Our reference: ECM Ref: 9878076
Contact: Kathryn Saunders
Telephone: (02) 4732 8567

3 February 2022

Response to Request for Advice - Kemps Creek Estate - SSD-9522-MOD3 at No. 657 Mamre Road, Kemps Creek

**Figure 4.2. Bakers Lane and New Access Road Intersection Arrangement**

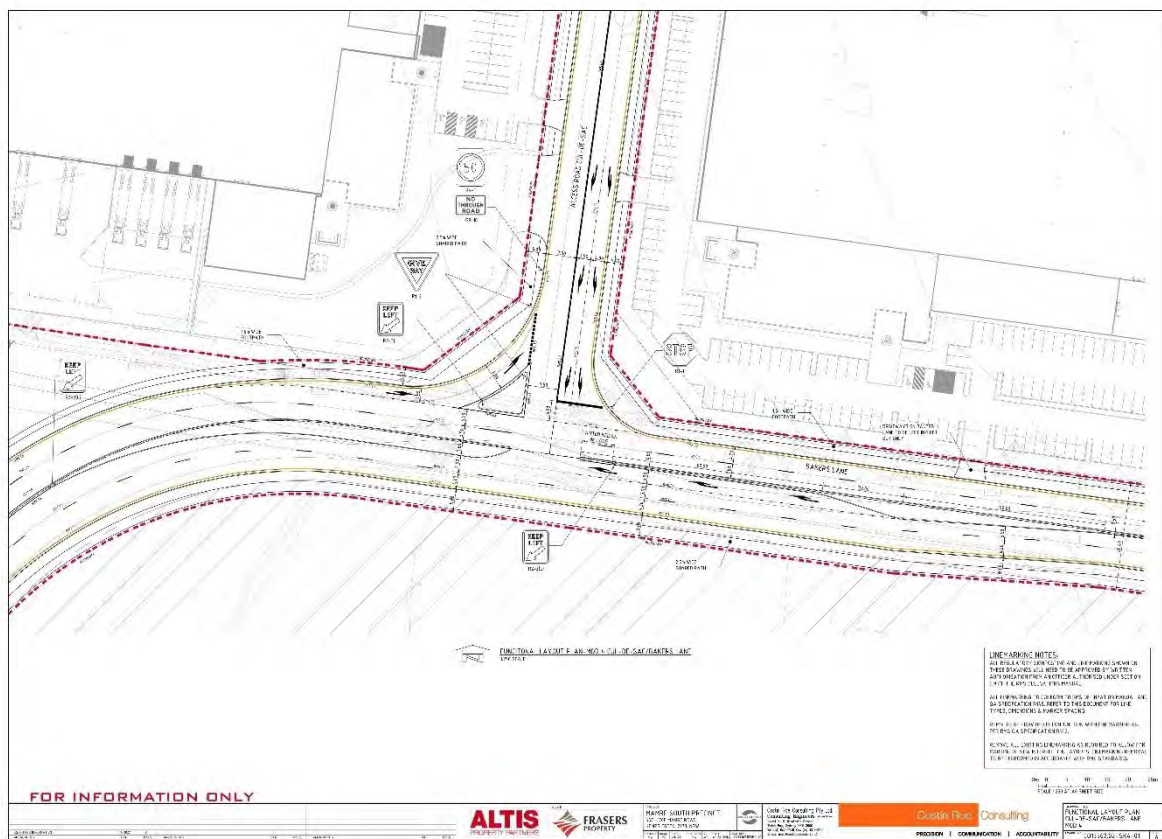
Section 8 of the Transport Assessment report shall include design review of the proposed left turn and right turn lanes at Bakers Lane / Access Road intersection, shall demonstrate that the turning lane lengths are designed in accordance with Austroads standards and storage length should be based on SIDRA results.

The Department is advised to seek explanation as to why a left turn slip lane is required at the intersection of Bakers Lane and the Access Road, noting that Figure 21 shows that only 1vph is turning left from Bakers Lane onto the Access Road.

DRAWING TITLE	TURNING PATHS PLAN-SHEET 3
	STAGE 2 INTERSECTION
	MOD 3
DRAWING No.	C013362 02-SK3-06

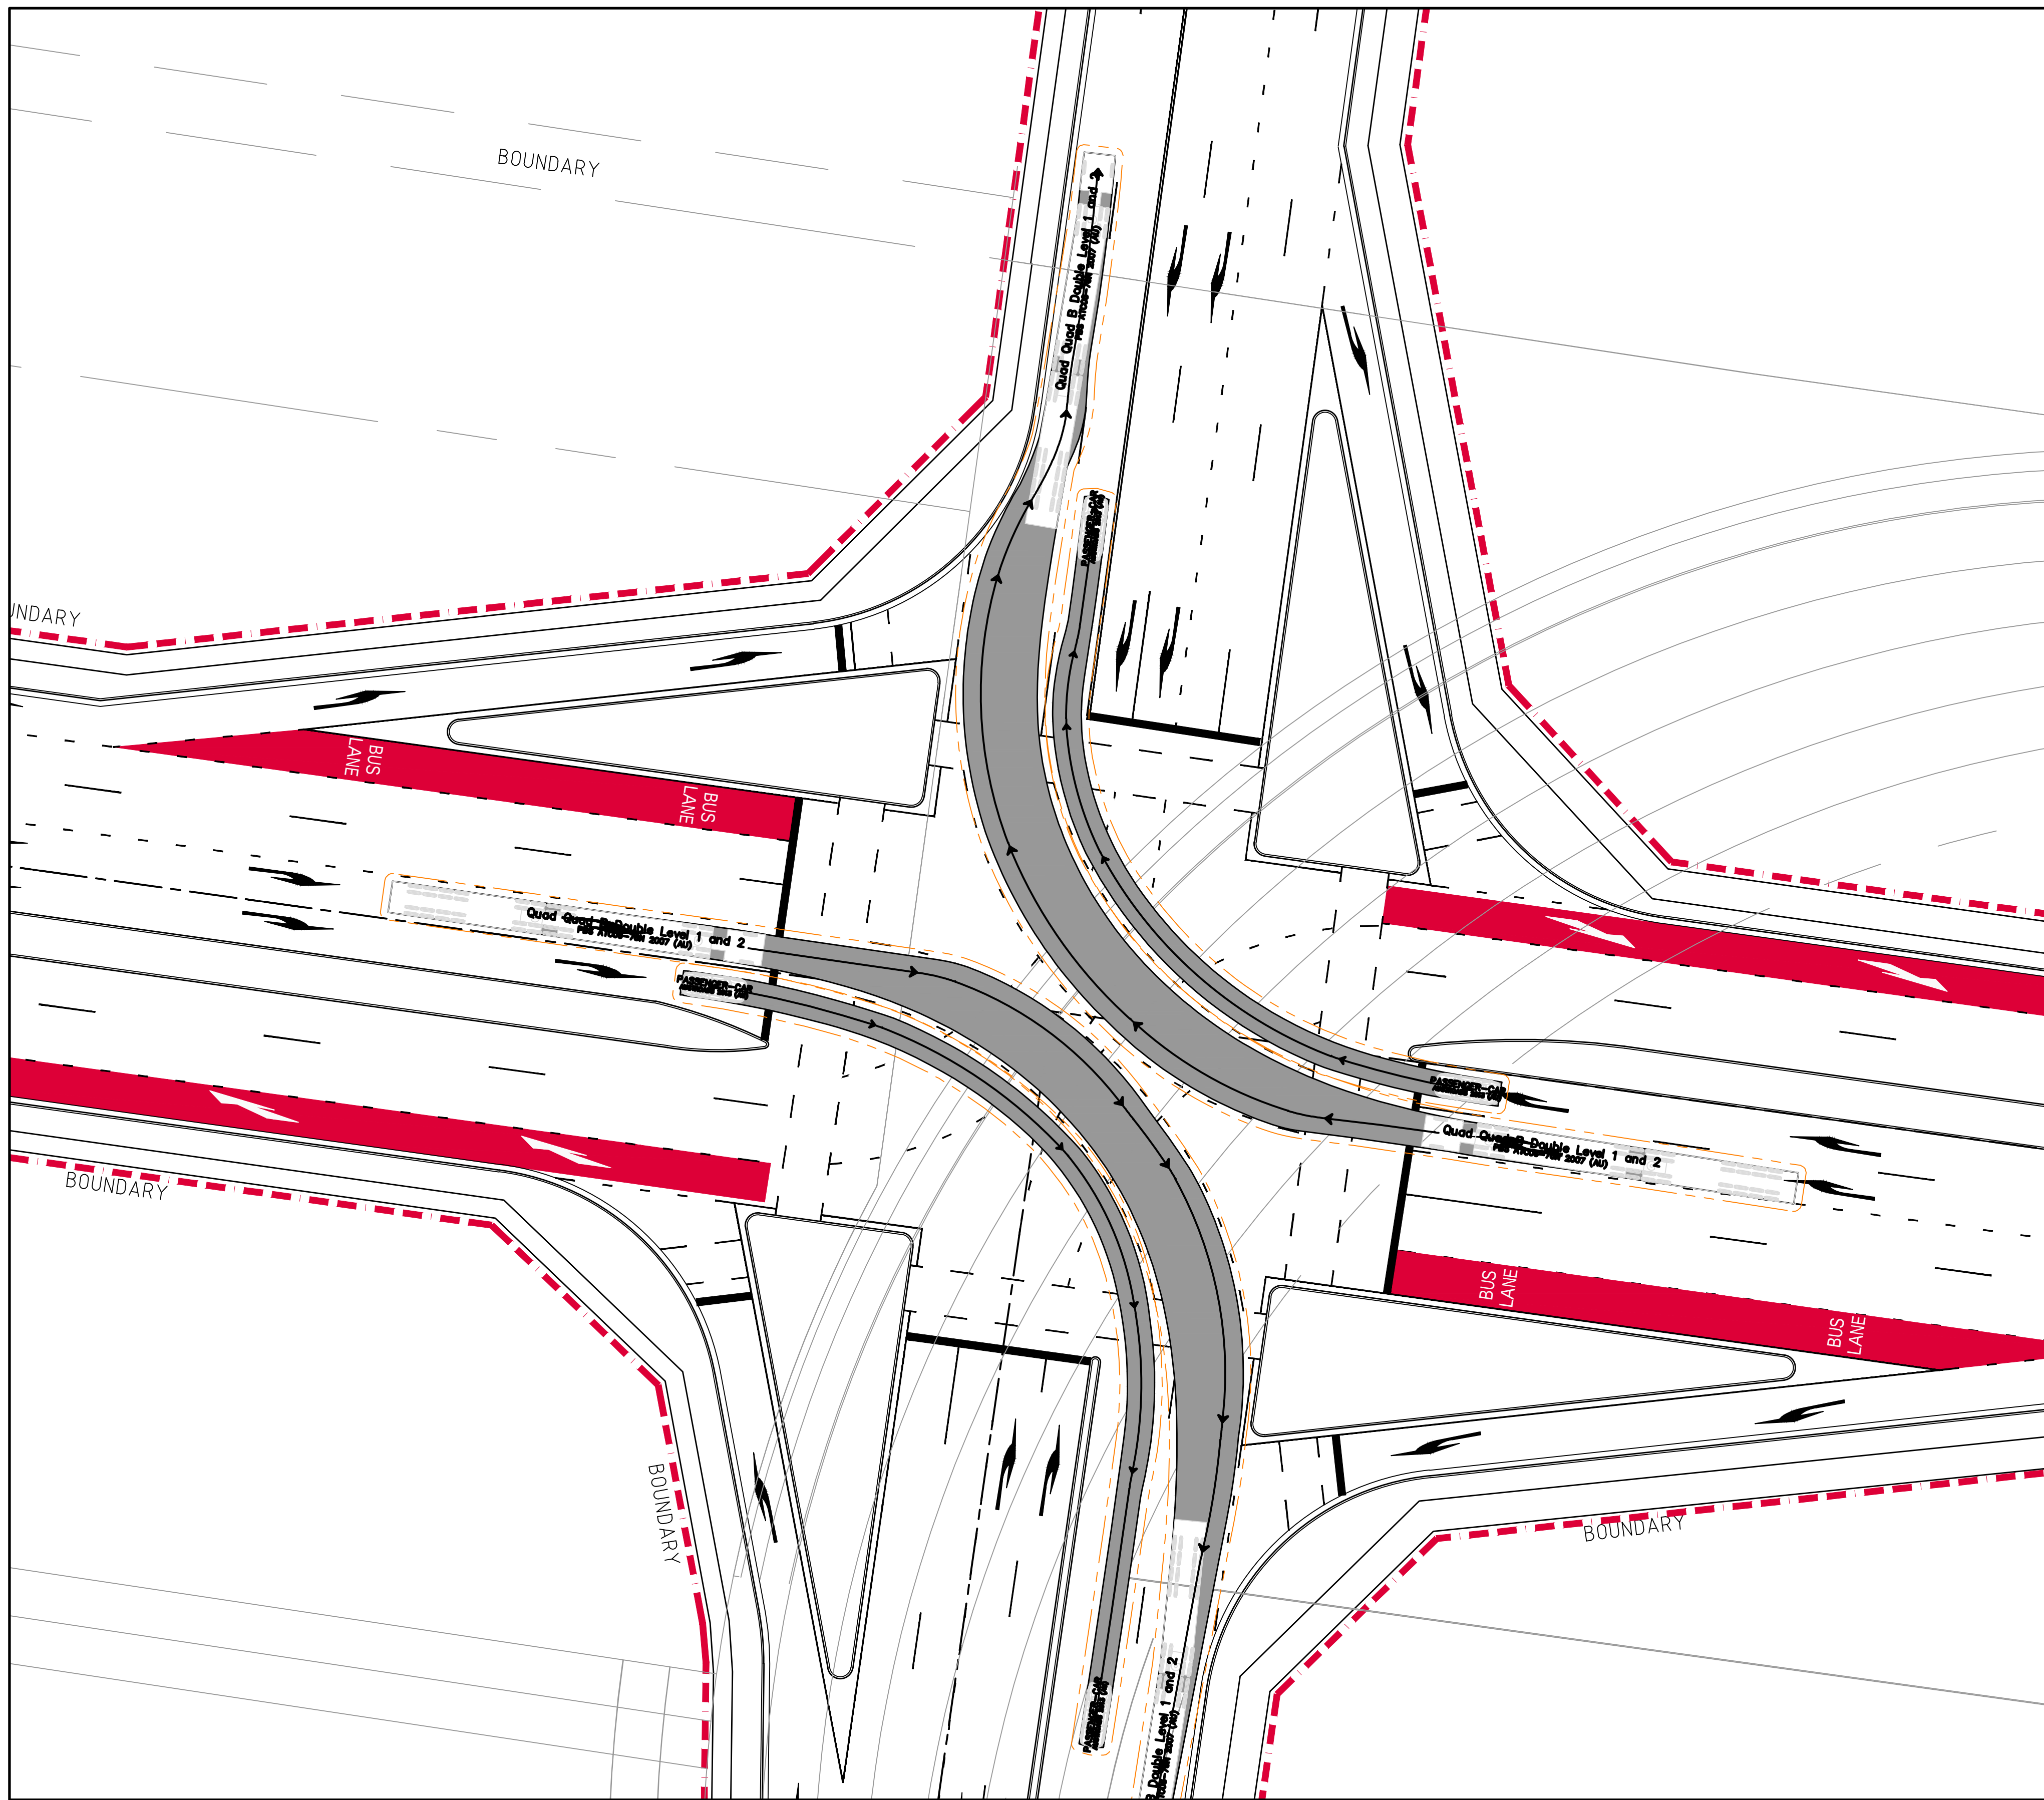
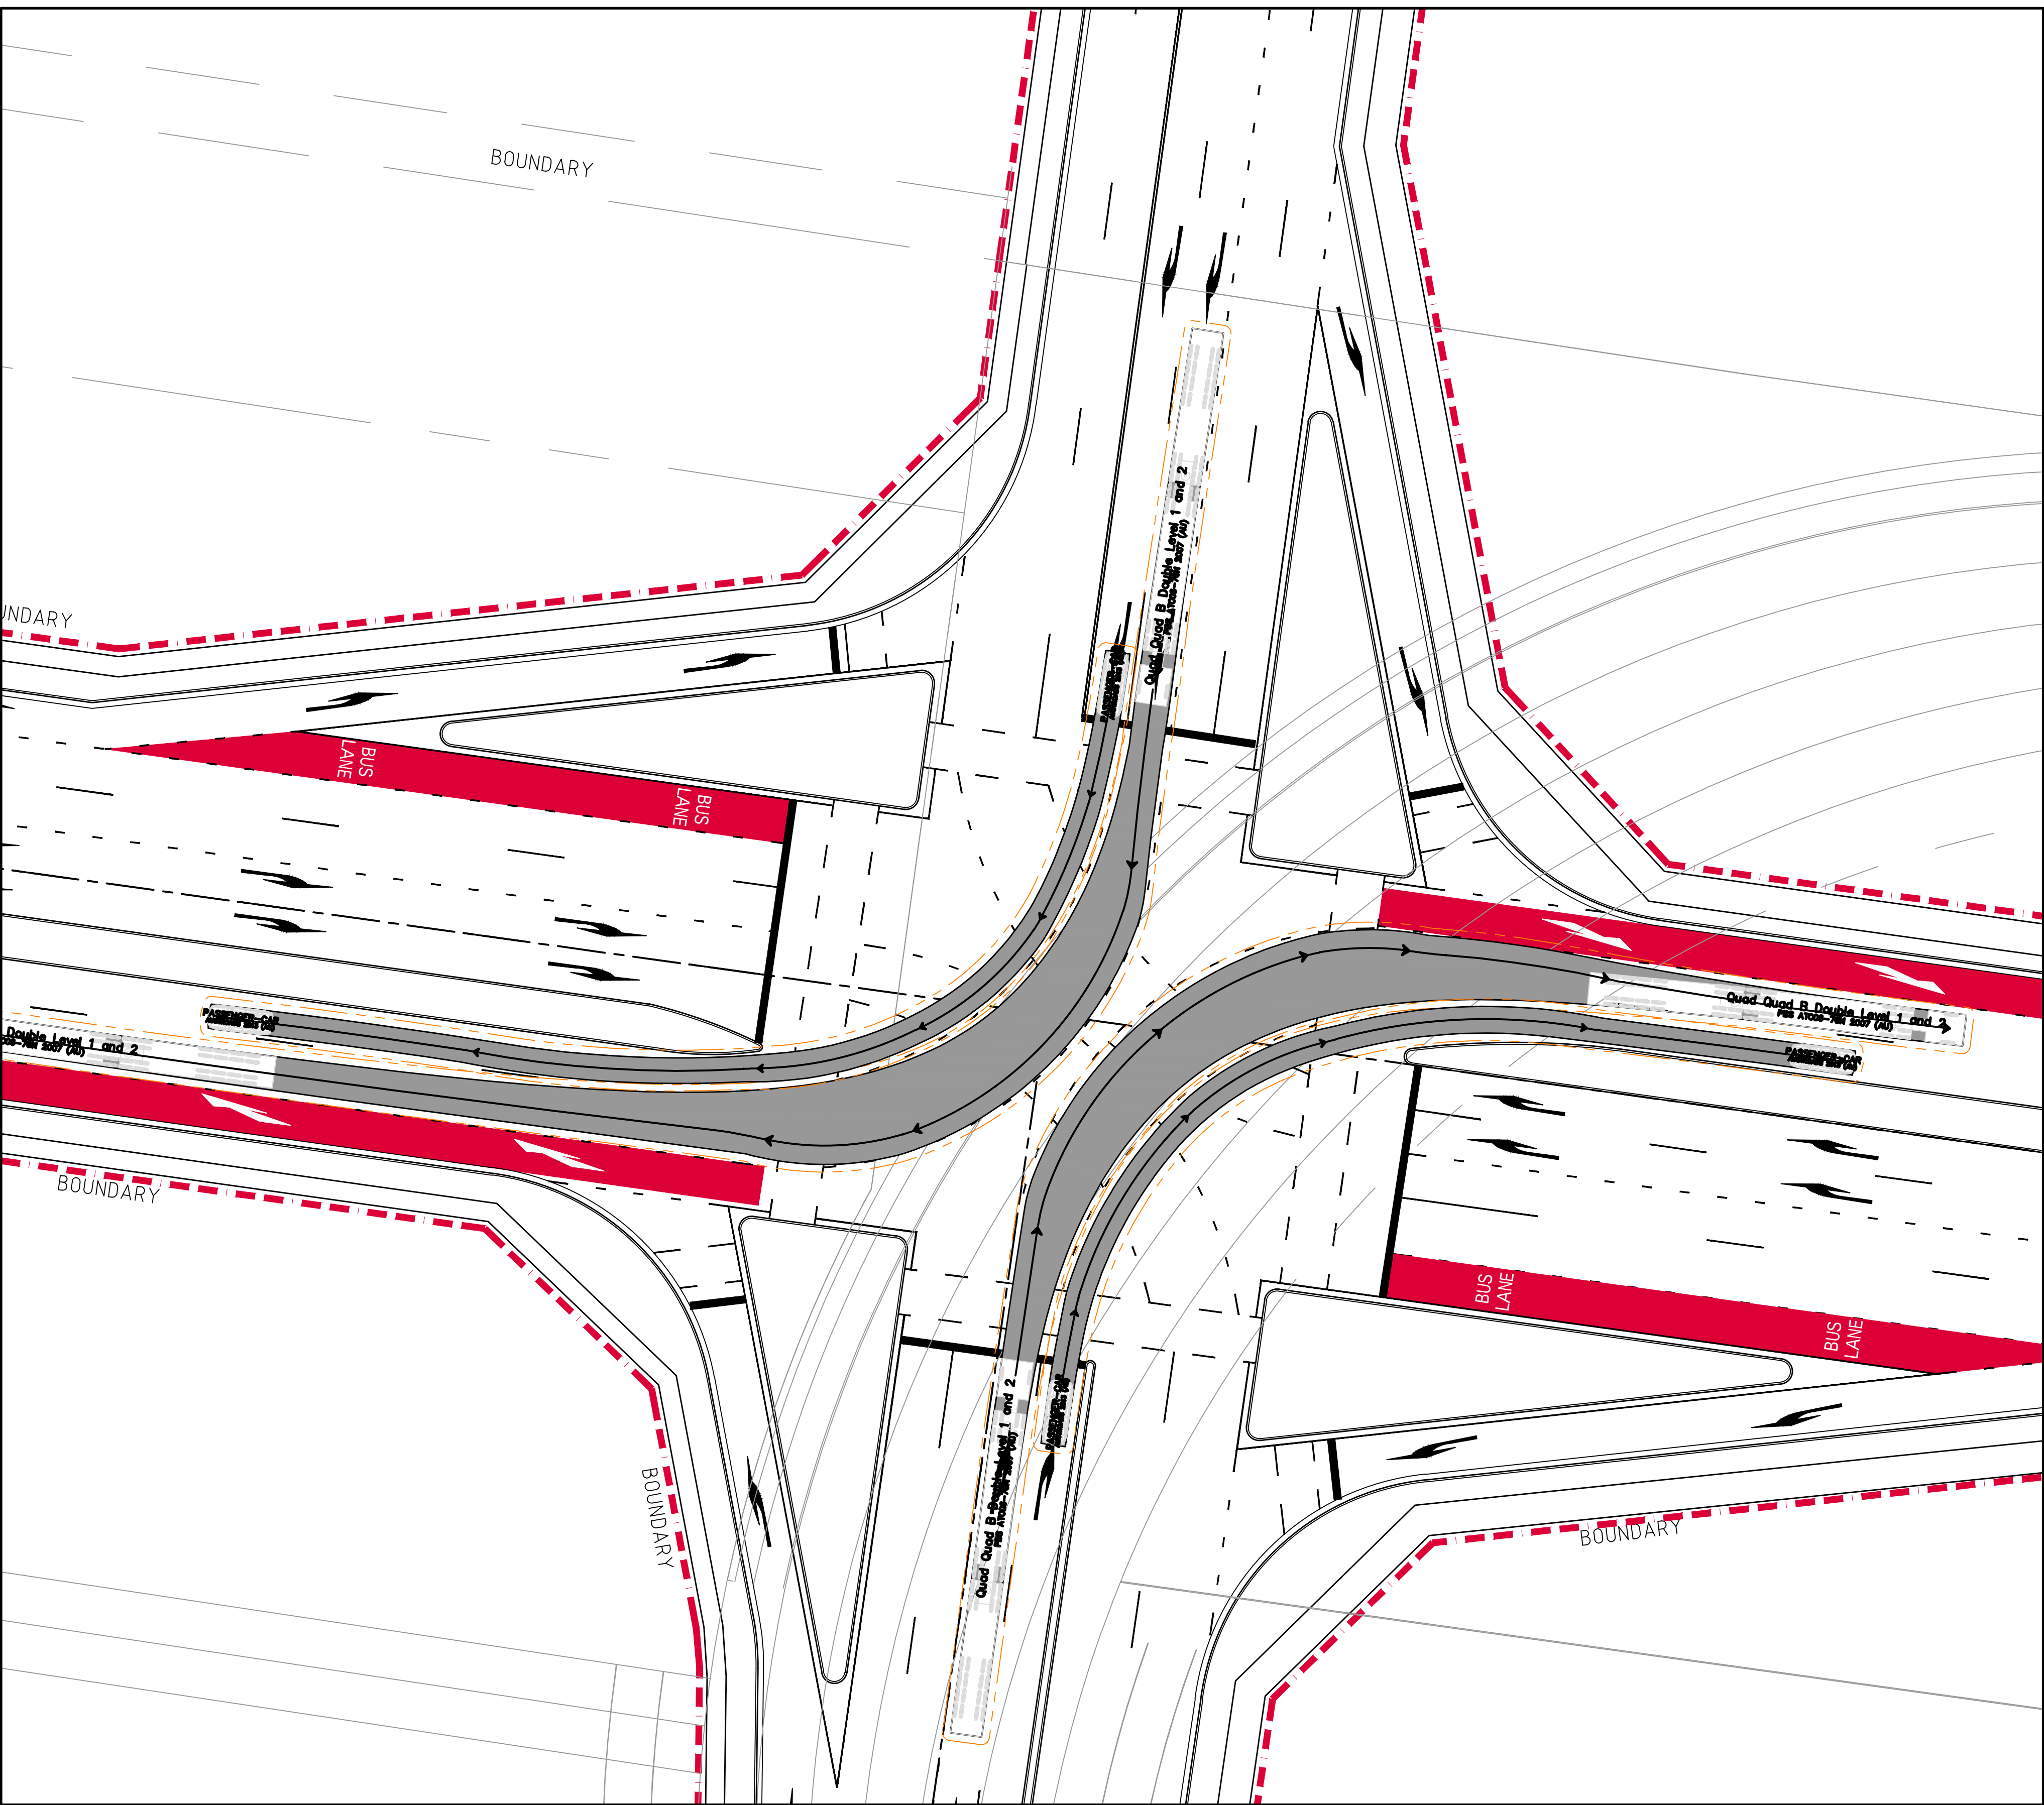
It is raised for the Department's consideration that the plans by Costin Roe Consulting, drawing numbers Co13362.02-SK4-06, SK4-07, SK4-08 & SK4-09 have not demonstrated that the future intersection and road network has been tested for a 36.5m PBS Level 3 Type A vehicle.
